From: Andrew Wood <Andrew.Wood@arun.gov.uk>
Sent: 05 January 2021 07:16
To: Planning.Responses <Planning.Responses@arun.gov.uk>
Subject: FW: AB/118/20/PL

AB/118/20/PL

70A Tarrant Street Arundel BN18 9DN

Extension to form 2 No. self-contained apartments

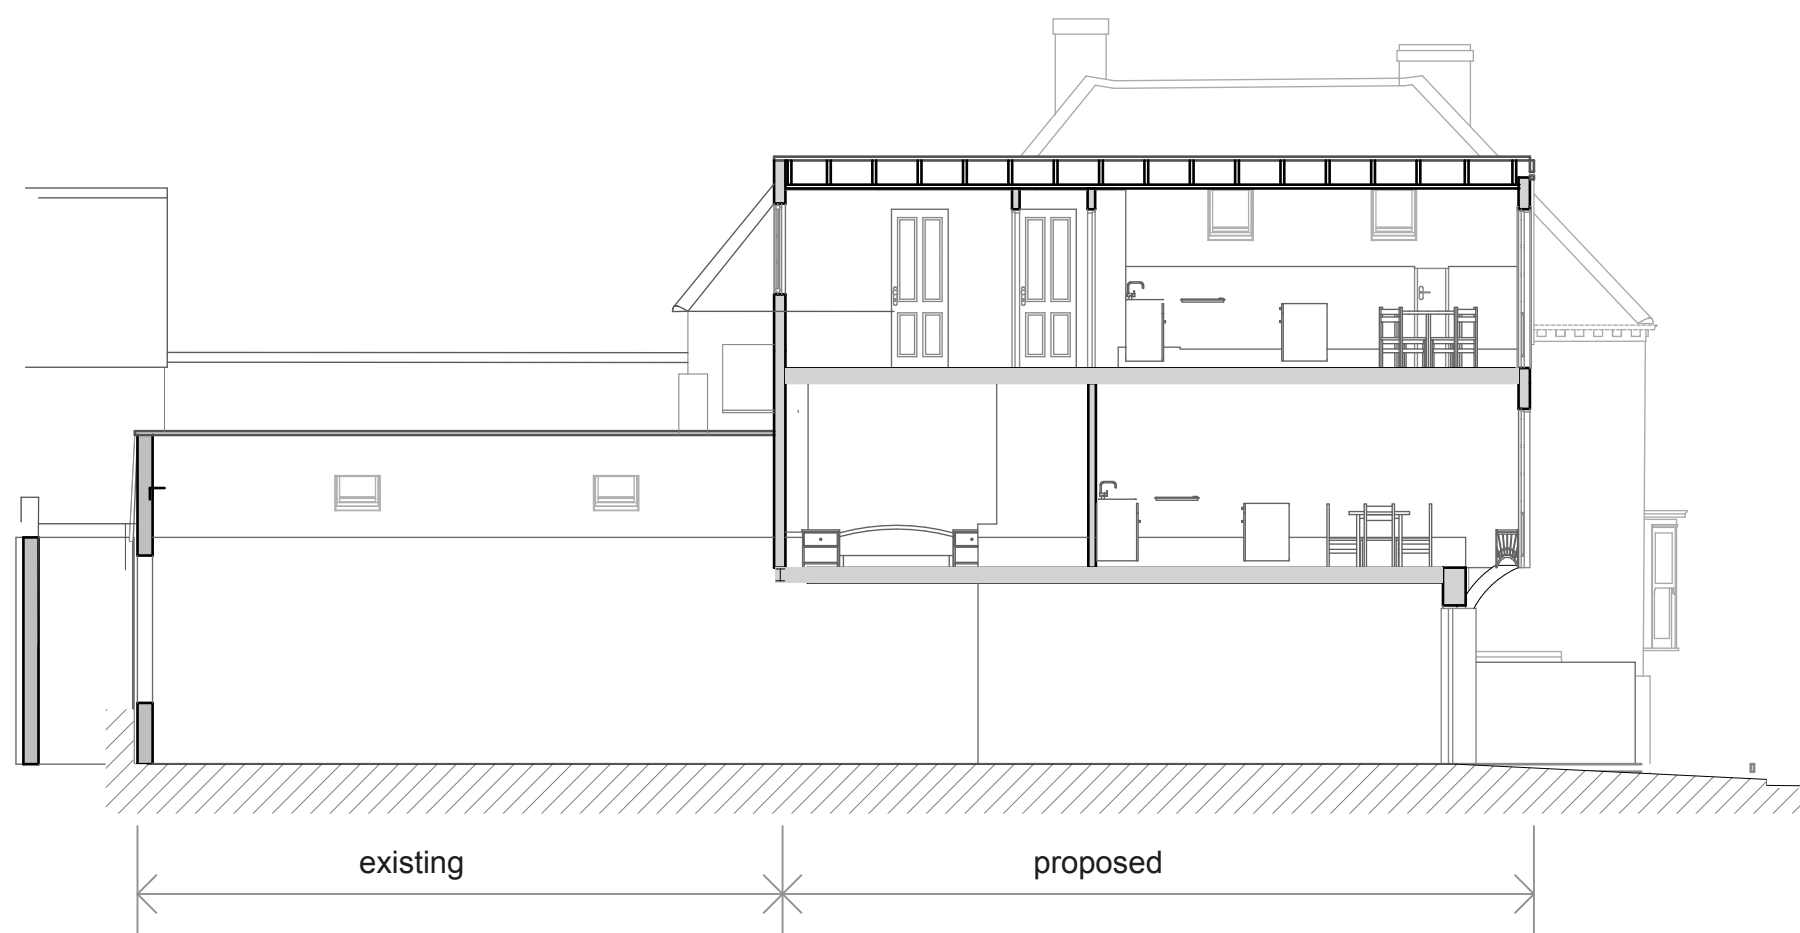
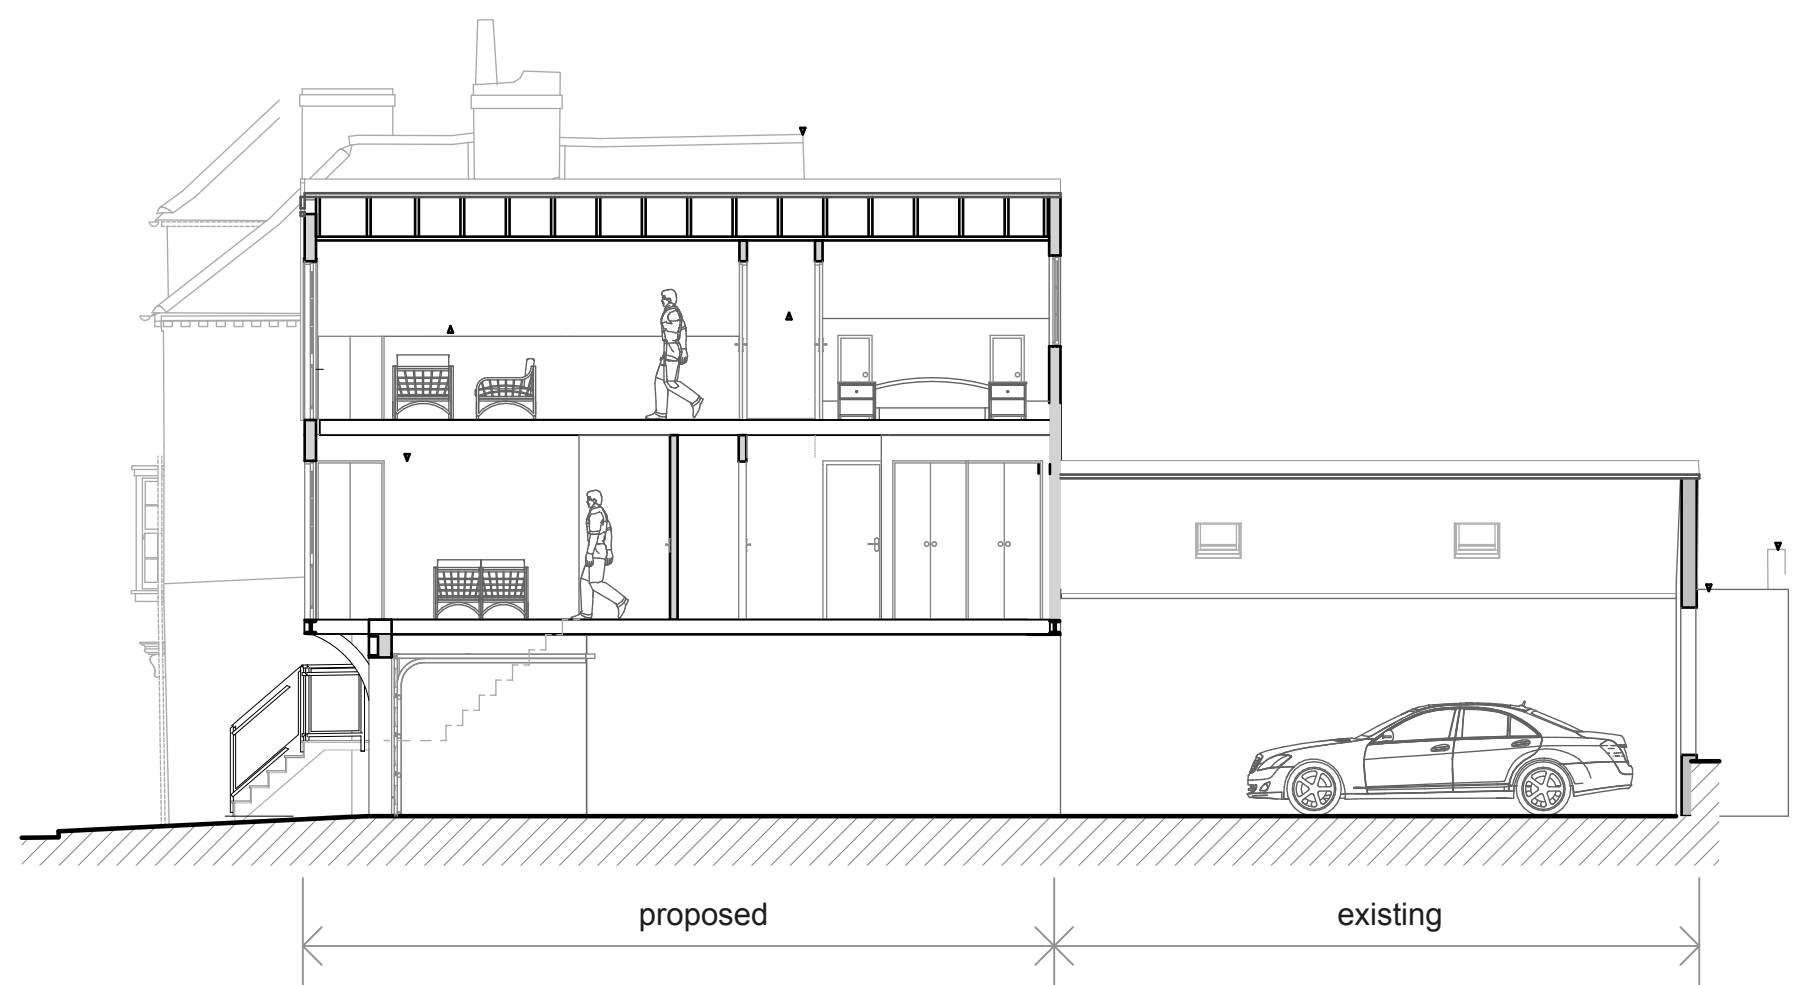
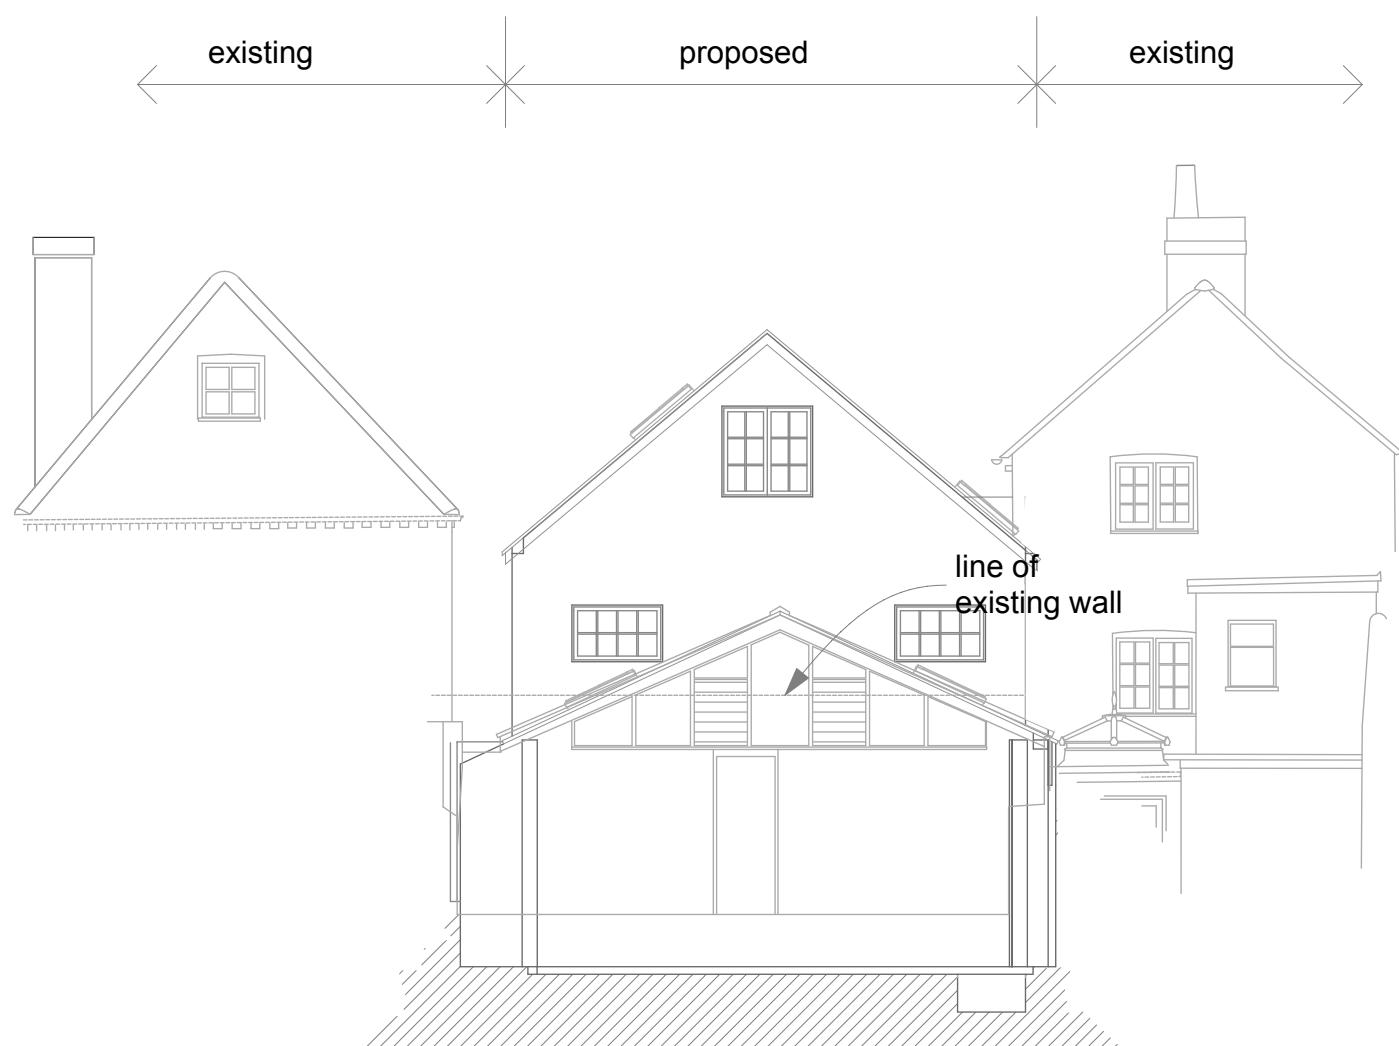
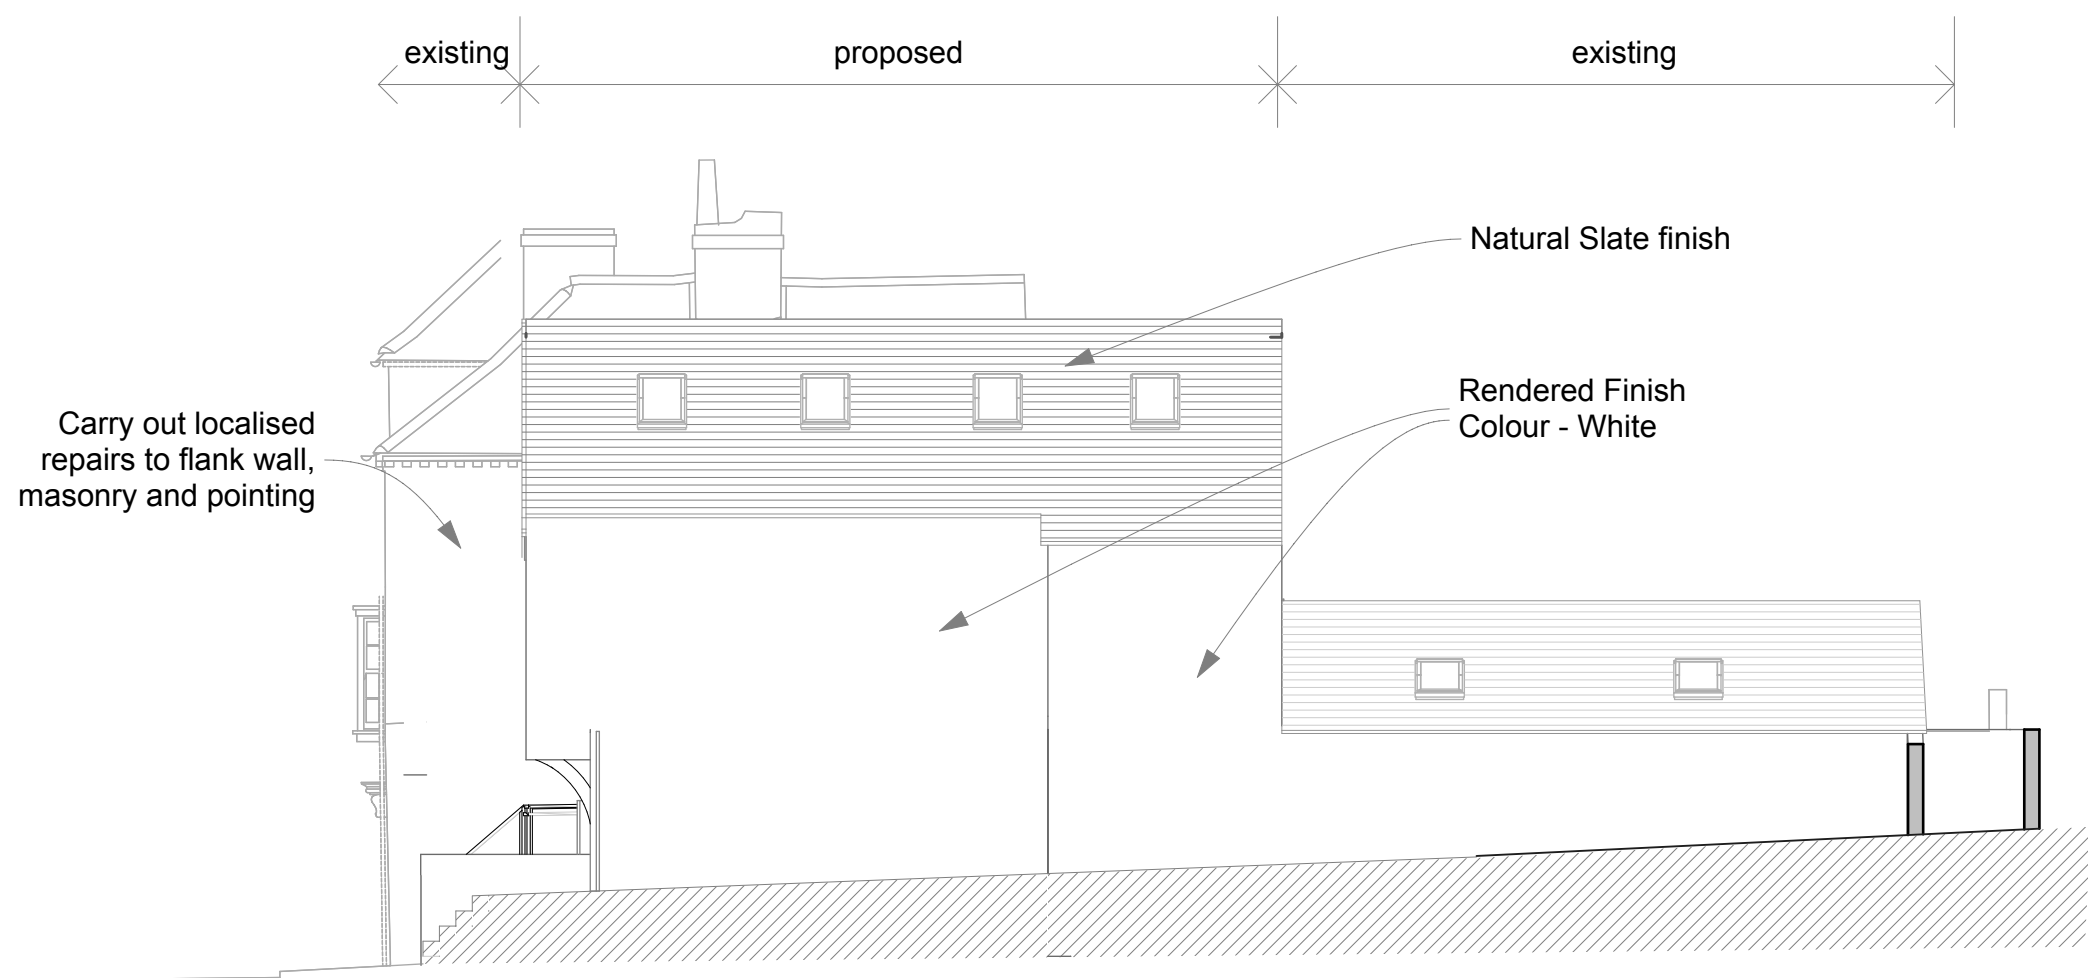
However, I also note reference to 'natural slate finish' on the plans for the roofing material and would want to be assured that slate would be used as opposed to a composite material. Likewise, I note references to the fact that all of the exterior will be treated with one grey colour. I am of the opinion that this requires clarification as the use of grey is not a traditional colour, and it is not clear why every surface would be the same shade/colour.

- Details of fenestration, including materials, operating mechanism and setback from the front face of external walling. Including details of the rooflights, which should be flush mounted and in a conservation style. Details should be at an appropriate scale and level of detail.
- Samples of the timber cladding, new external brickwork, and the natural slates for the roof of the building.
- Precise details of the bargeboards and eaves – provided to an appropriate scale/level of detail.
- Precise details of the external staircase and balustrading shown provided to the street elevation of the building – provided to an appropriate scale/level of detail.
- Details of the external treatment of the building – i.e. the colour following the concerns I raised earlier.
